APPROVAL REQUIRED BY CONDITION OF PERMISSION

Reference:	H08-0045-25	Date of Decision:	1st April 2025
Applicant:	713 Homes Ltd 2 Herdsman'S Close Deeping St Nicholas Spalding Lincolnshire PE11 3AE		
Location:	Adj 3 Bow Gate Gosberton Spalding Lincolnshire		
Description:	Details of external materials, existing and proposed site levels, proposed floor levels, landscaping, tree planting, proposed boundary treatments, surface water disposal, foul water disposal and Biodiversity Net Gain Plan (Conditions 3, 5, 6, 7, 8, 9 and 10 of H08-0183-24)

South Holland District Council hereby give notice that the use, operations or matter as specified in the application, is REFUSED within the meaning the Town and Country Planning Act 1990 (as amended), for the following reason(s):-

Scale: 1:10, 1:50, 1:100, 1:200, @ A1 Drawing: AWM Checked: TAC Date: 10/01/2025 Drawing No: 24/673/PA/001

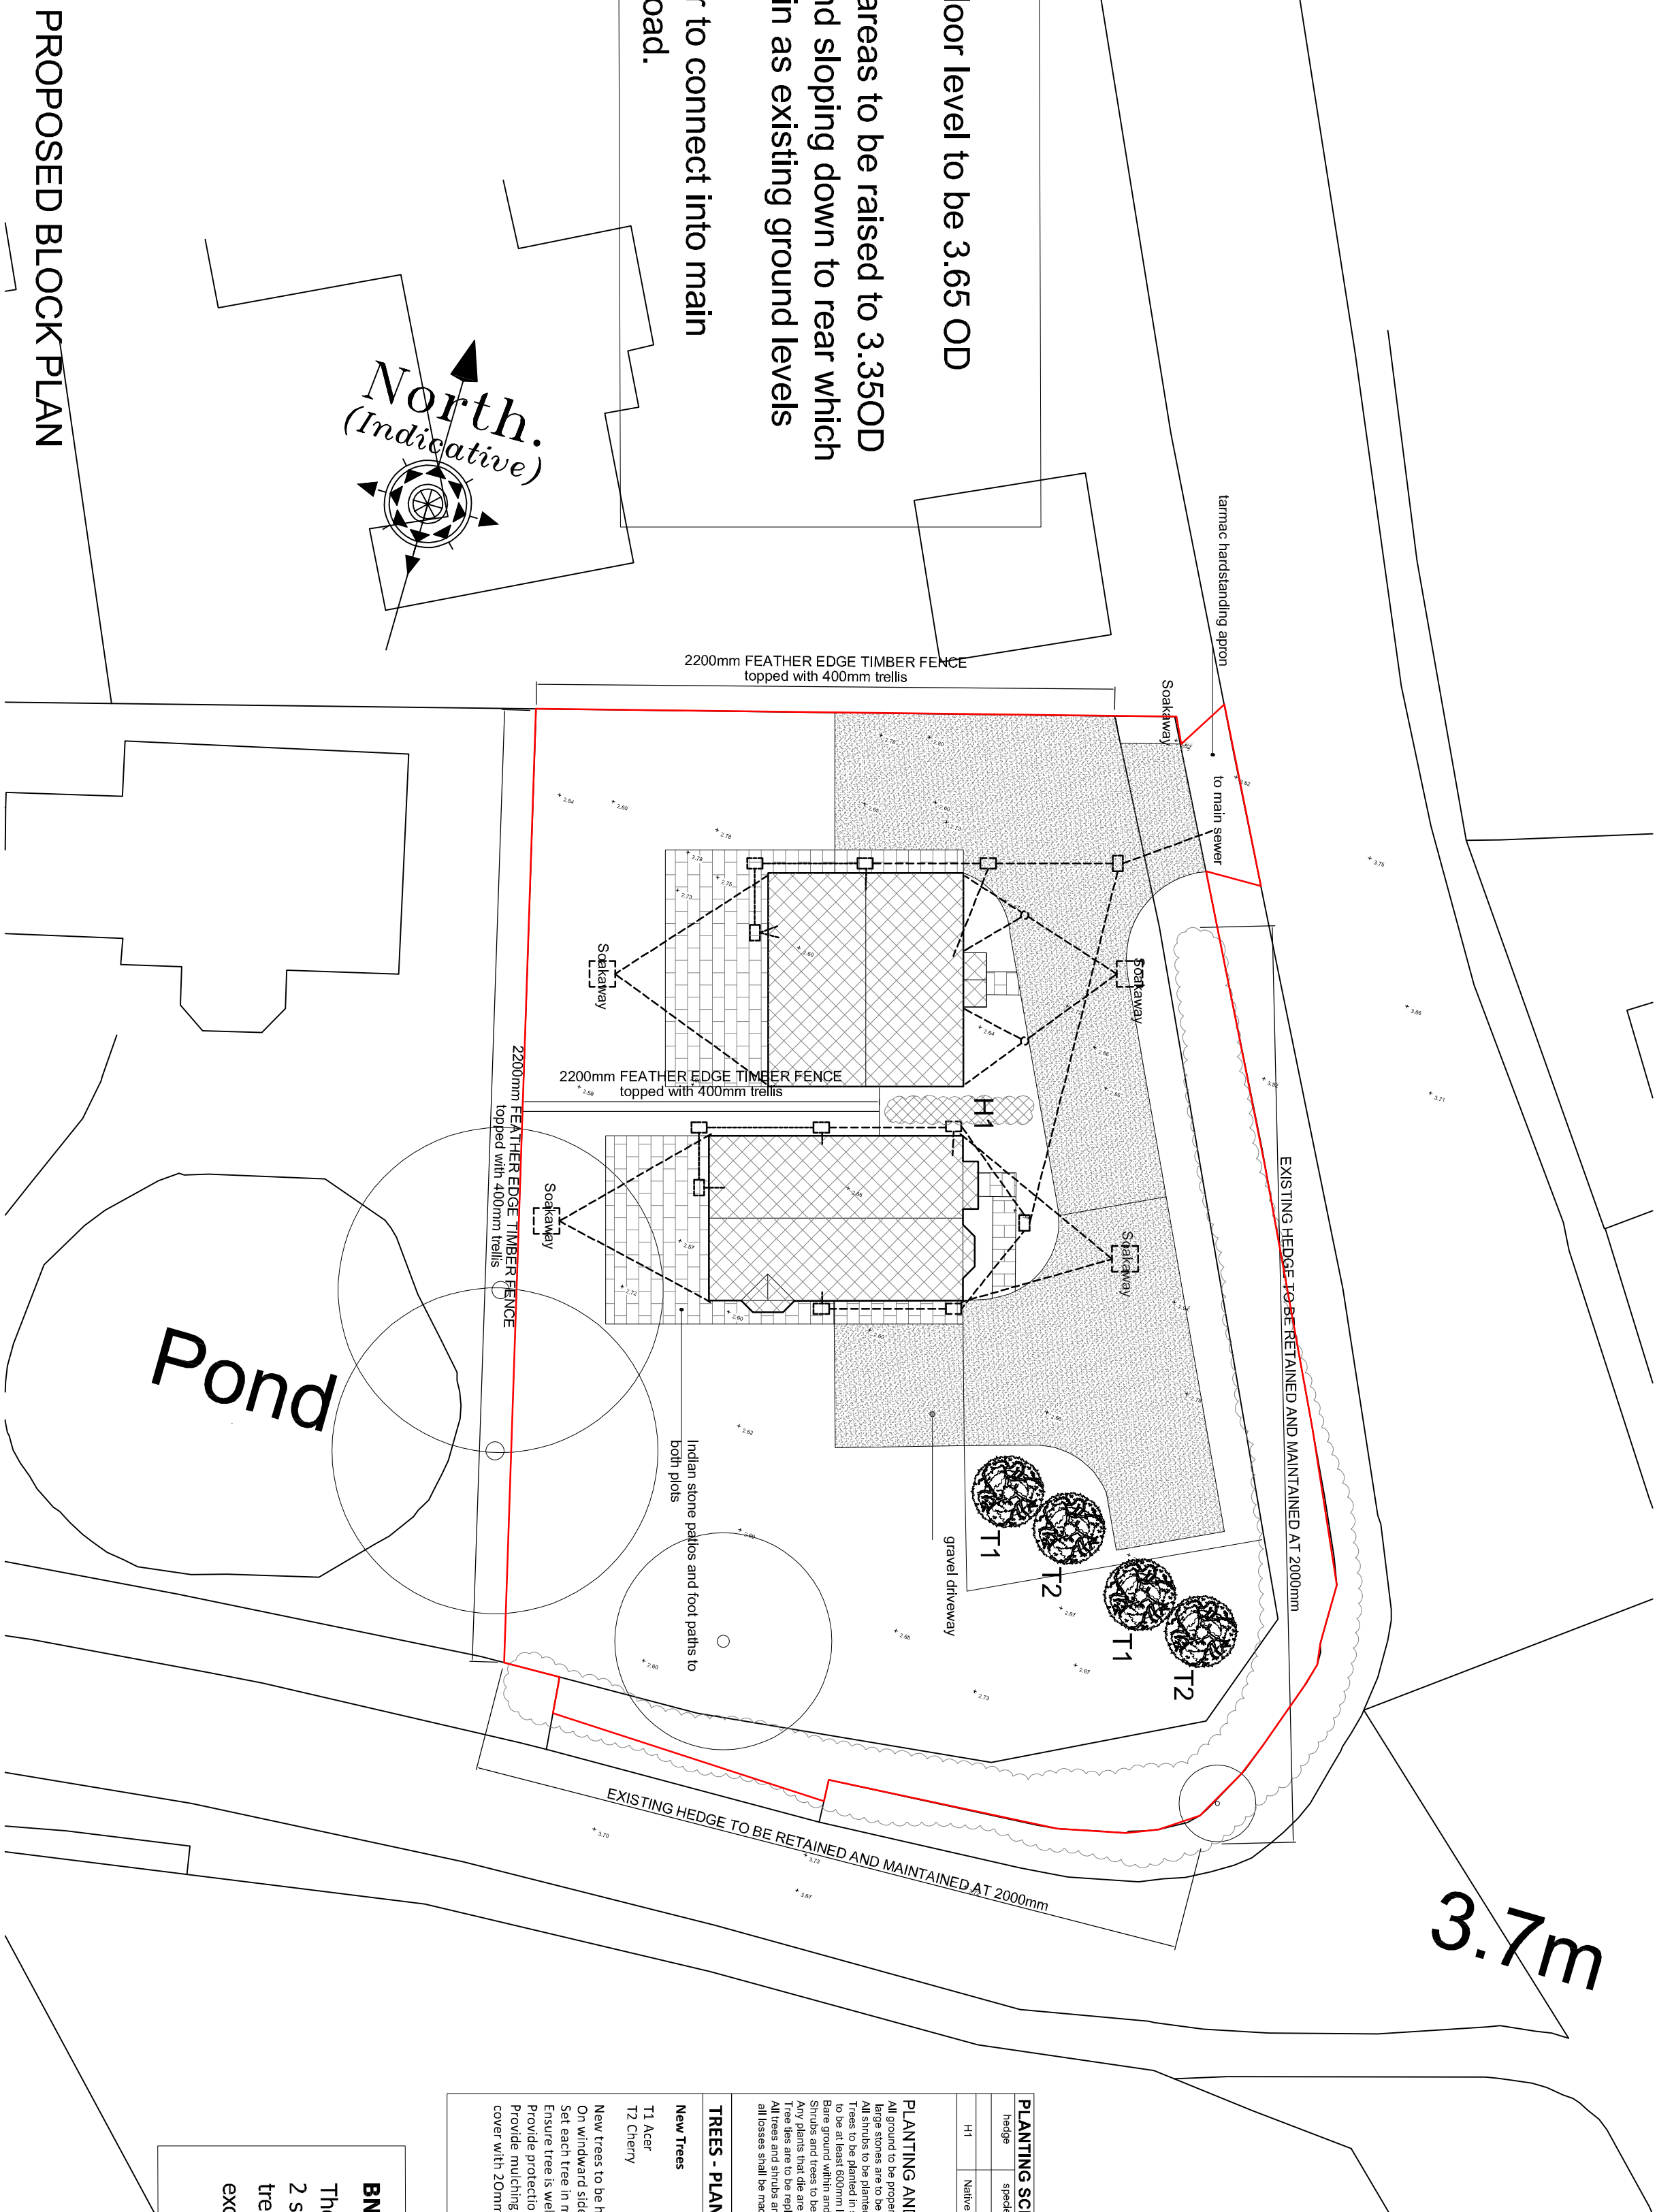
- 1 In the opinion of the Local Planning Authority, insufficient information has been provided in respect of the details required for Conditions 5, 6, 7, 8, and 10 of H08-0183-24. Therefore, due to the inadequate information, it has not been possible for the Local Planning Authority to adequately ensure the suitability of the details proposed; therefore, Conditions 3, 5, 6, 7, 8, 9 and 10 of H08-0183-24 are not discharged, and the details are not approved.
- 2 The proposed use of Clipsham stone is considered inappropriate in this setting; with the selected material failing to reflect the prevailing character of the area. As such, it is considered that the details relating to Condition 3 of H08-0183-24 are unacceptable and therefore this condition is not discharged.
